From: Sue Howell
Sent: 29 July 2014 16:07
To: Planning.Responses
Cc: Damian Sullivan
Subject: RE: Planning Consultation on: LU/177/14/PL

Comment from Greenspace

Landscape

SITE PLAN WITH DRAFT LEVELS
 PROPOSED RESIDENTIAL DEVELOPMENT
 THE OLD DAIRY, CHURCH STREET, LITTLEHAMPTON, SUSSEX.
 GRAHAM NICOLLS LIMITED, DESIGN + TECHNOLOGY, TEL/07990 522709

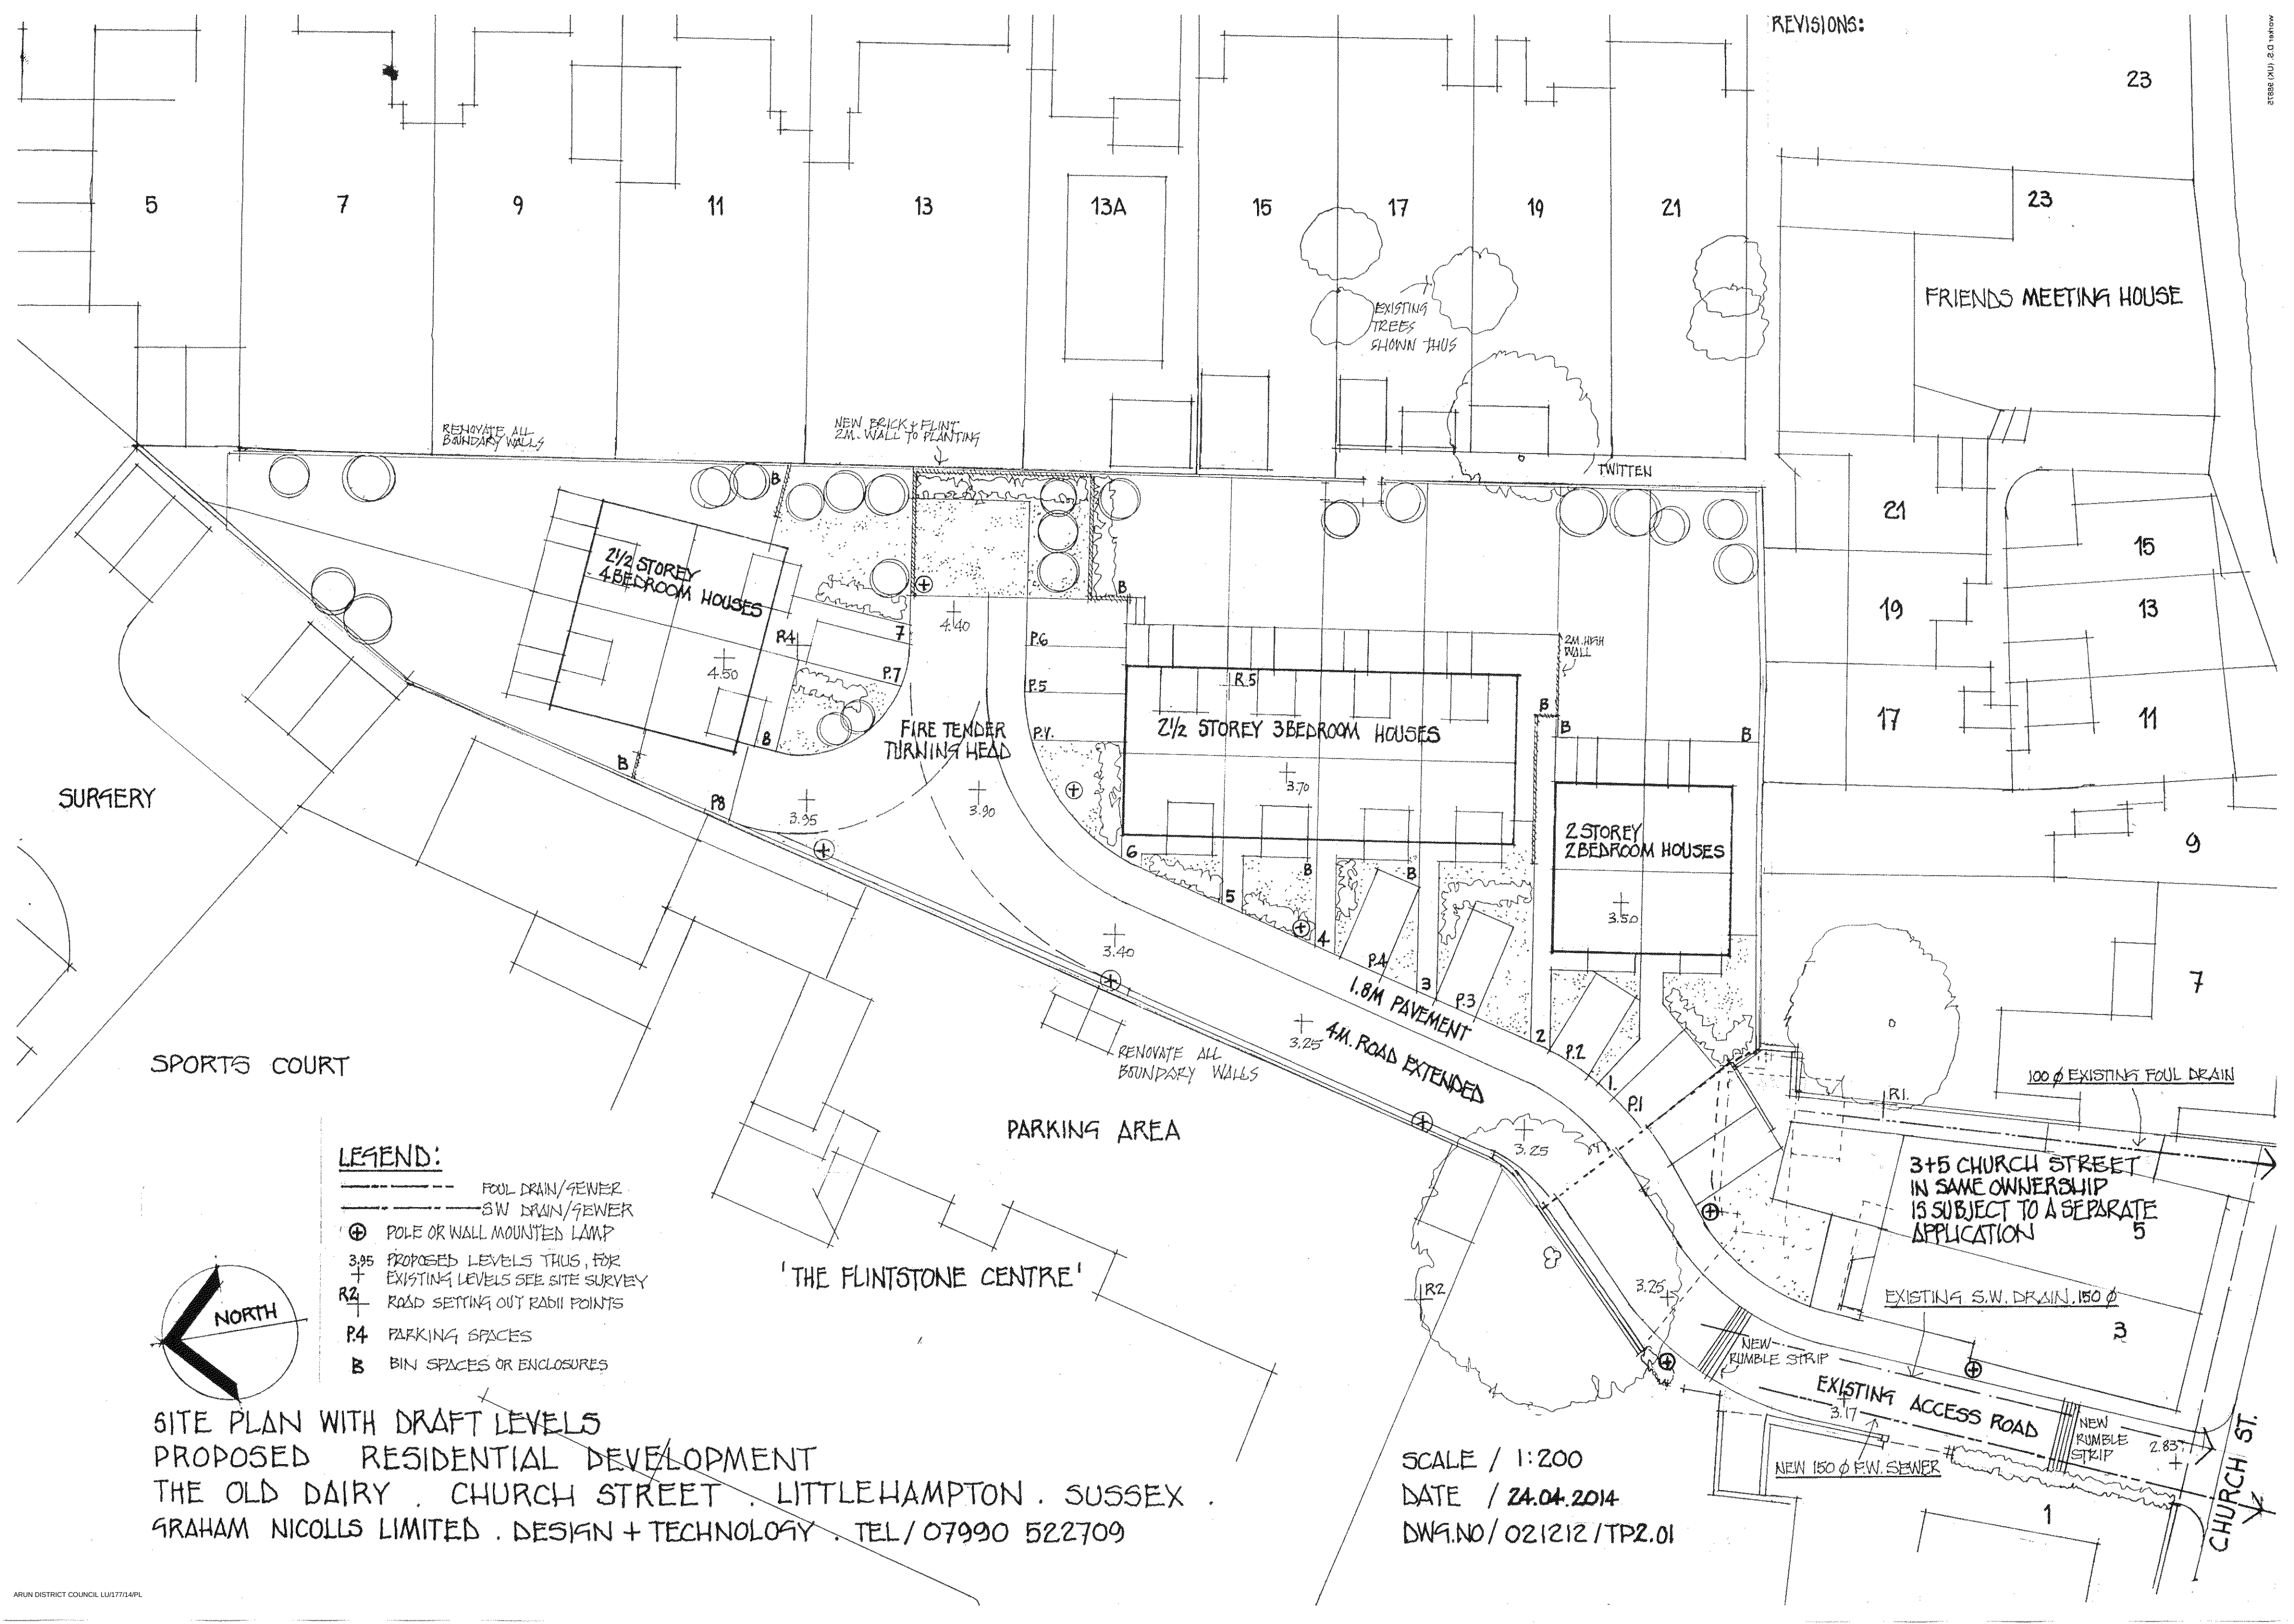
Forming part of the application and prior to any consent being given a full landscape scheme should be submitted for approval, detailing species choice, position, densities and size at time of planting. This should be plotted in plan and list form and in relation to the trees and vegetation to be retained in the locale, so that a clear picture of the proposals can be seen. These details are required to assure the adjacent land setting is maintained, the setting is uncompromised and the proposals are appropriate to its setting. This development is situated in a conservation area and adjacent to listed buildings so a scheme that is appropriate to setting will be sought.

Any trees or vegetation in particular along the boundaries, which adjoin neighbouring land could provide potential valuable screening and should be retained particularly those adjoining the settlement boundary. Any considered tree removal from this site should be agreed with Arun District Councils Tree Officer. Root protection Areas (RPA) should extend into the development site and to those in neighbouring land. Before construction, a tree protection scheme must be in place for any (If any) retained trees including trees whose root protection areas fall within the construction zone from neighbouring land. This should be in accordance with BS 5837:2012 'Trees in relation to construction'
